# CITY OF ALBUQUERQUE

**RE: Baca Duplexes  
Grading and Drainage Plan  
Engineers Stamp Date 6/7/14 (G14-D080)**

GRADING & DRAINAGE PLAN

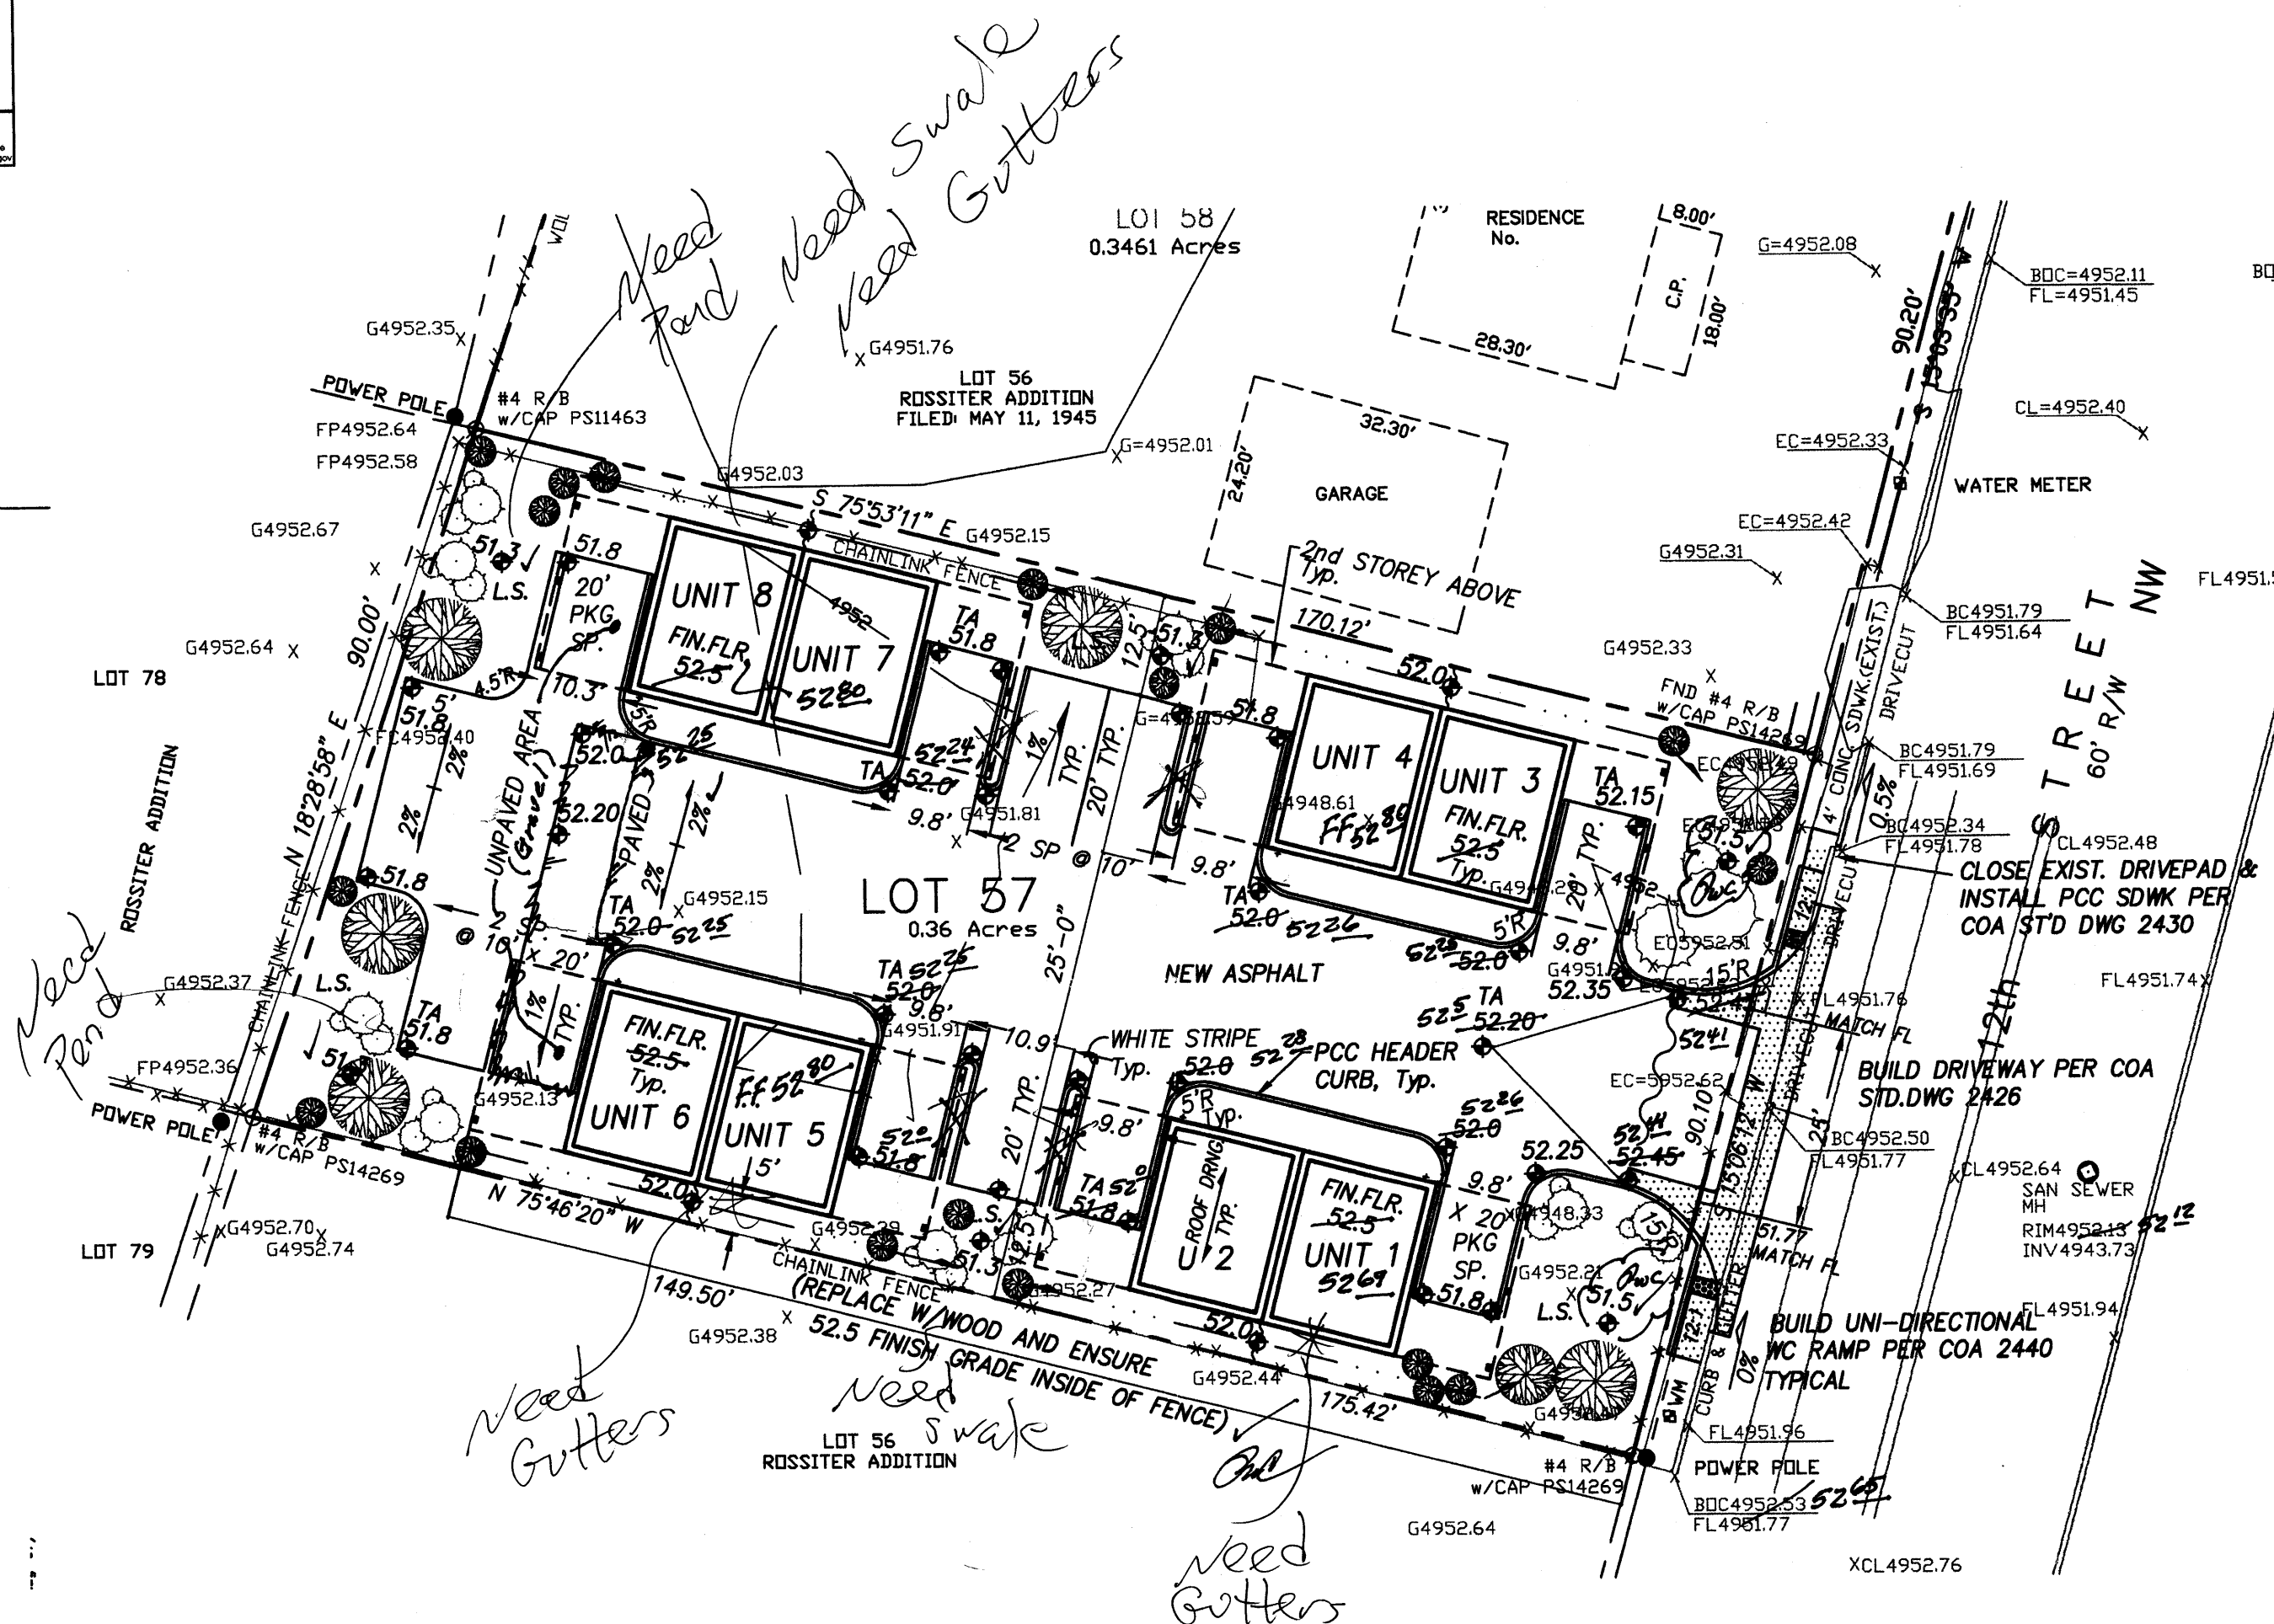
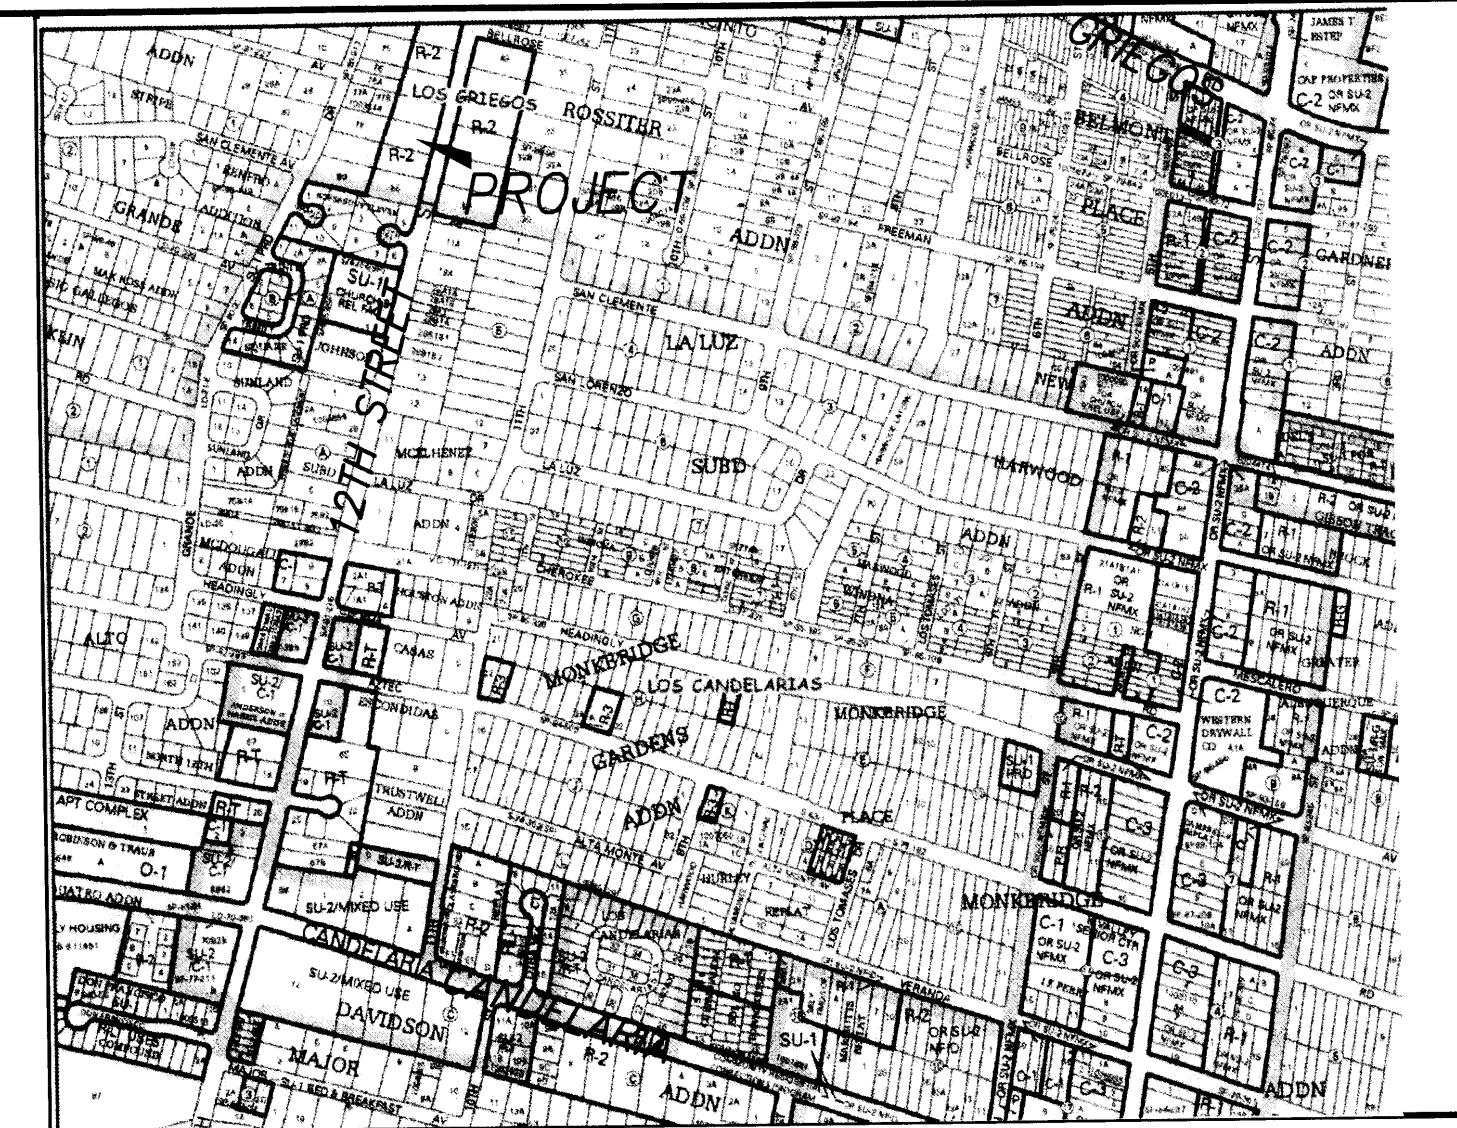
- Show the direction roof flows.
- Since this site is in the valley, a discharge of 2.75 cfs/acre is allowed. In this case 1 cfs is allowed to discharge; therefore the depressed landscaped area volumes should be increased.
- The plan is to manage the first flush which is the runoff from a .44" storm. This may be accomplished by draining all impervious areas to the depressed landscaped areas.
- How are the flows leaving the landscaped areas on the west and east ends of this site? All flows should be directed to leave toward the east via a swale and exit the site via a sidewalk culvert or a curb cut by the drive way.
